IMAX REDEVELOPMENT – DEVELOPMENT NUMBER SSD 5397. 31 WHEAT ROAD, SYDNEY

**Assessment of proposed IMAX Redevelopment, Darling Harbour
The Ribbon, 31 Wheat Road, Sydney**

Application No. SSD- 5397

Figure 2. Public Domain Comparison Plan

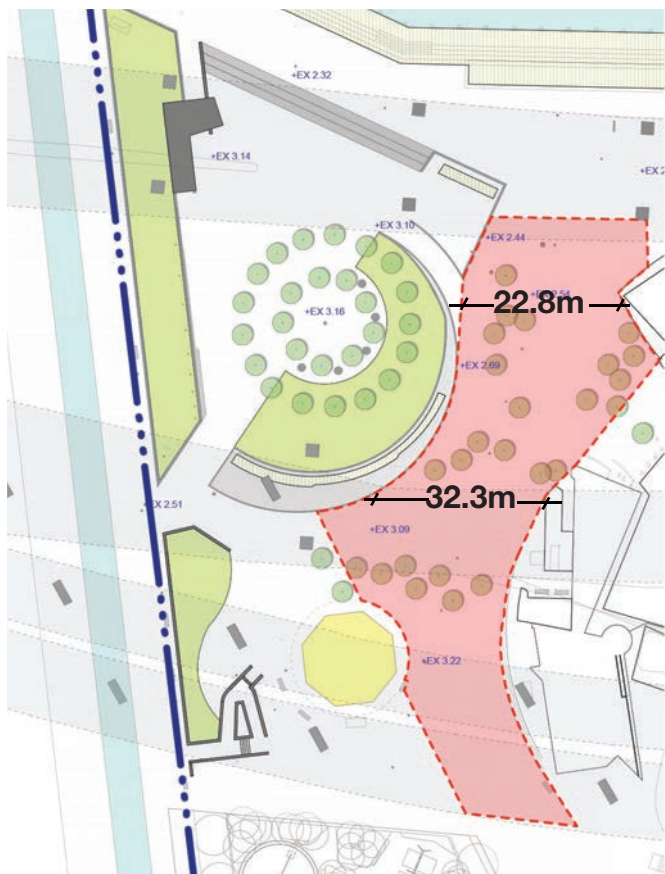
1. Reduces the amount of available open space by approximately 830m²
2. Increases the population at this location by approximately 3,500 - 4,000 people
3. Constricts major pedestrian routes at key points

'There should be no reduction in the available open space from what is available on the site today, ideally it should be increased'

Accessible public open space in the vicinity of the IMAX redevelopment is proposed to be reduced by approximately 830m². This reduction in open space will not only reduce the pedestrian capacity of this key part of Darling Harbour, but constricts the pedestrian connectivity both in the north-south promenade direction and the east-west city link direction.

Modifications to the lower levels of the proposal would be relatively straightforward to address these issues as outlined in the north-south pedestrian connections and City/Darling Harbour connectivity sections of this report.
